Application Ref:	3/2025/0525			 Ribble Valley Borough Council www.ribblevalley.gov.uk
Date Inspected:	N/A	Site Notice:	N/A	
Officer:	LW			
DELEGATED ITEM FILE REPORT:				APPROVAL

Development Description:	Non-material amendment to planning permission 3/2020/0163 involving a change from render finish to corten steel cladding to the lower front balcony wall and alterations to fenestration design to front elevation.
Site Address/Location:	42 Painter Wood, Whalley Old Road, Billington, BB7 9JD.

EXISTING AND PROPOSED
ELEVATIONS FRONT

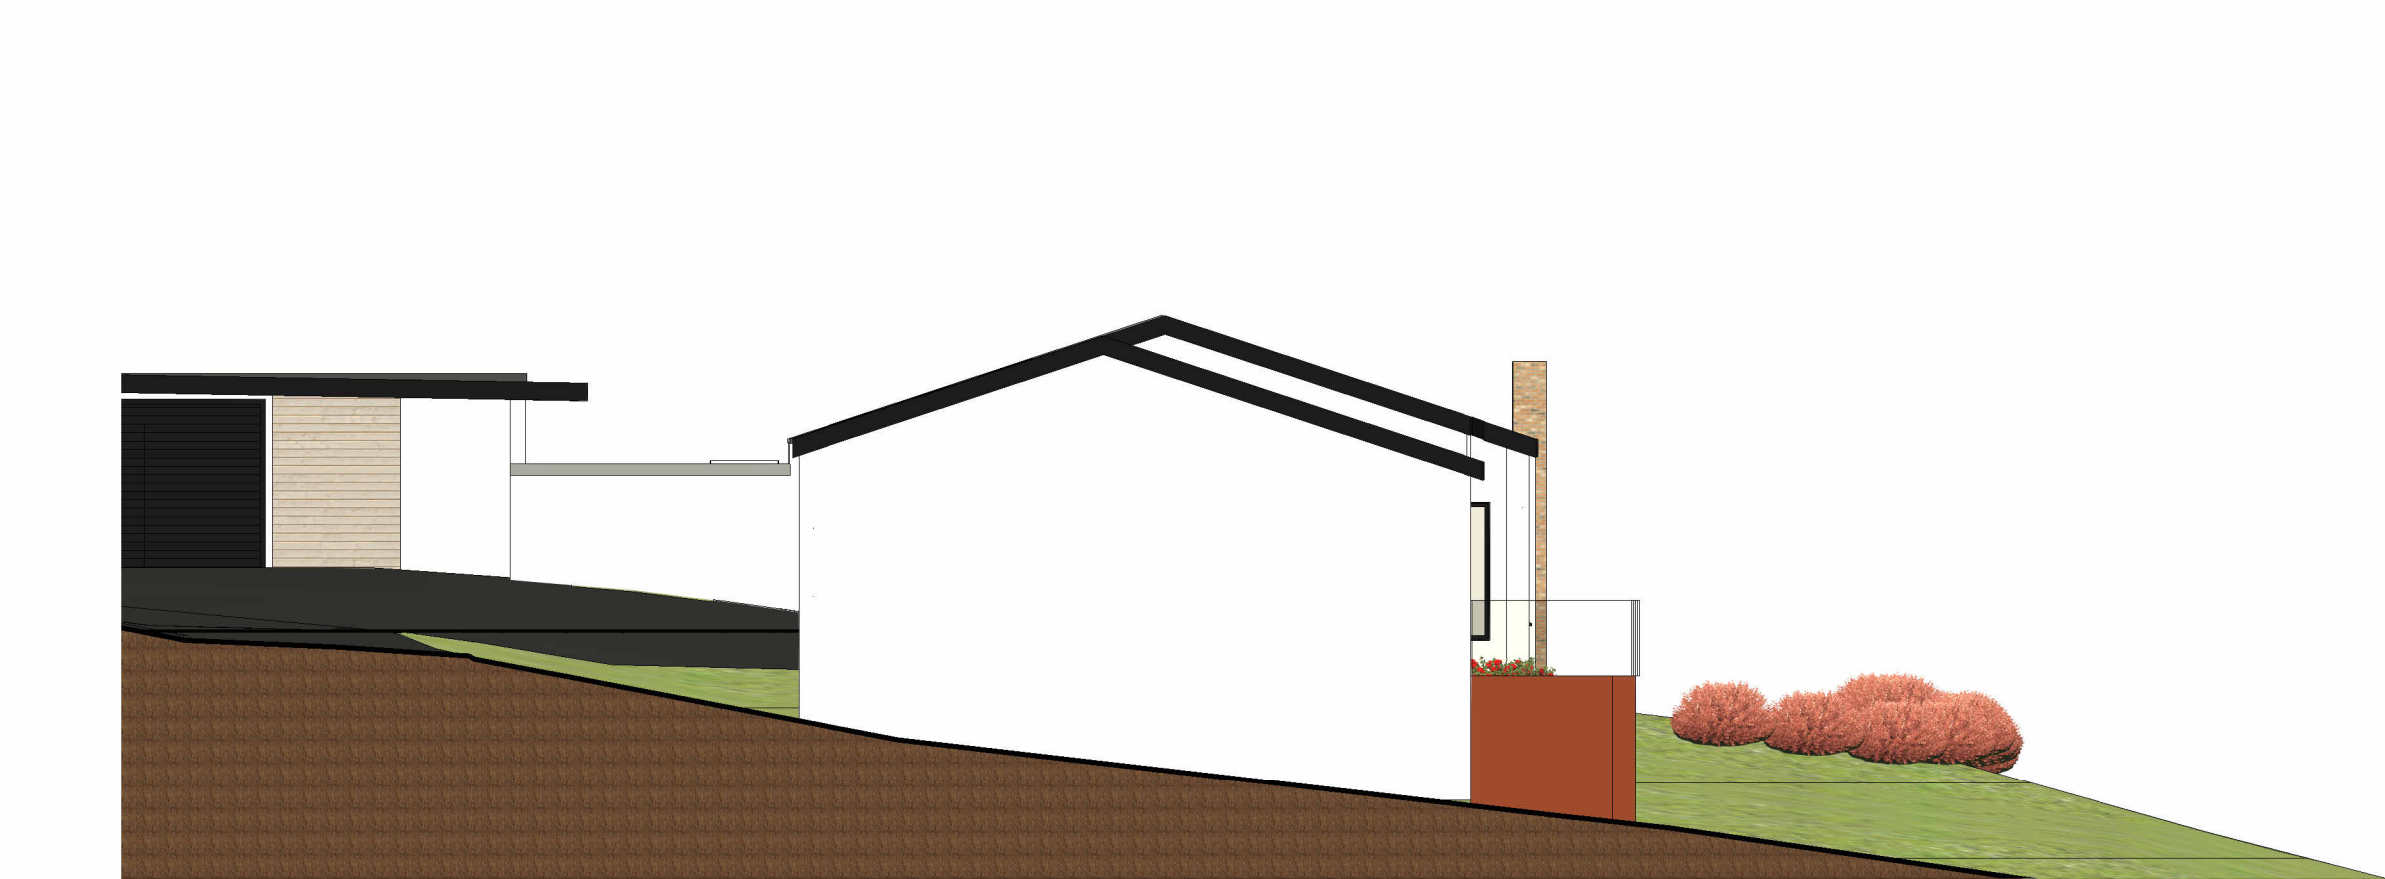
The amendments sought relate to the regularisation of the fenestration design and a proposed change in material for the lower balcony wall to the principal elevation of the dwellinghouse from the originally approved render to Corten steel cladding.

The amendment to the fenestration design is considered minor in nature and would not amount to a development that is materially different, in terms of external appearance and impact upon residential amenity, to that of the original consent. As such, it is considered that this amendment would in this case be non-material.

With respect to the proposed amendment to the balcony walling, the application's supporting information states that the existing render is staining and therefore it is proposed to replace this with steel cladding. However, whilst the contemporary style of the application dwelling and nearby built form is acknowledged, the principal elevation of the application property comprises render and timber cladding and therefore the incorporation of steel cladding is not considered to appear in keeping with the external facing materials of the existing dwellinghouse, nor would it reflect the materials featured within the surrounding area. This impact would only be exacerbated by the prominent siting of the application property along Painter Wood, with the dwelling also sited in an elevated position when viewed from the public highway.

Accordingly, it is considered that the visual impact of the amendment sought to the balcony would result in a fundamental change to the design and external appearance of the development originally approved, with the amendment proposed amounting to a development that would be materially different in terms of design and external appearance to that of the original consent.

In view of the above, it is therefore considered that the proposed amendment would in this case exceed the threshold of a non-material alterations to the original planning permission for the purposes of Section 96A of the Town and Country Planning Act 1990 (as amended).

RECOMMENDATION:	That the non-material amendment be refused.
------------------------	---
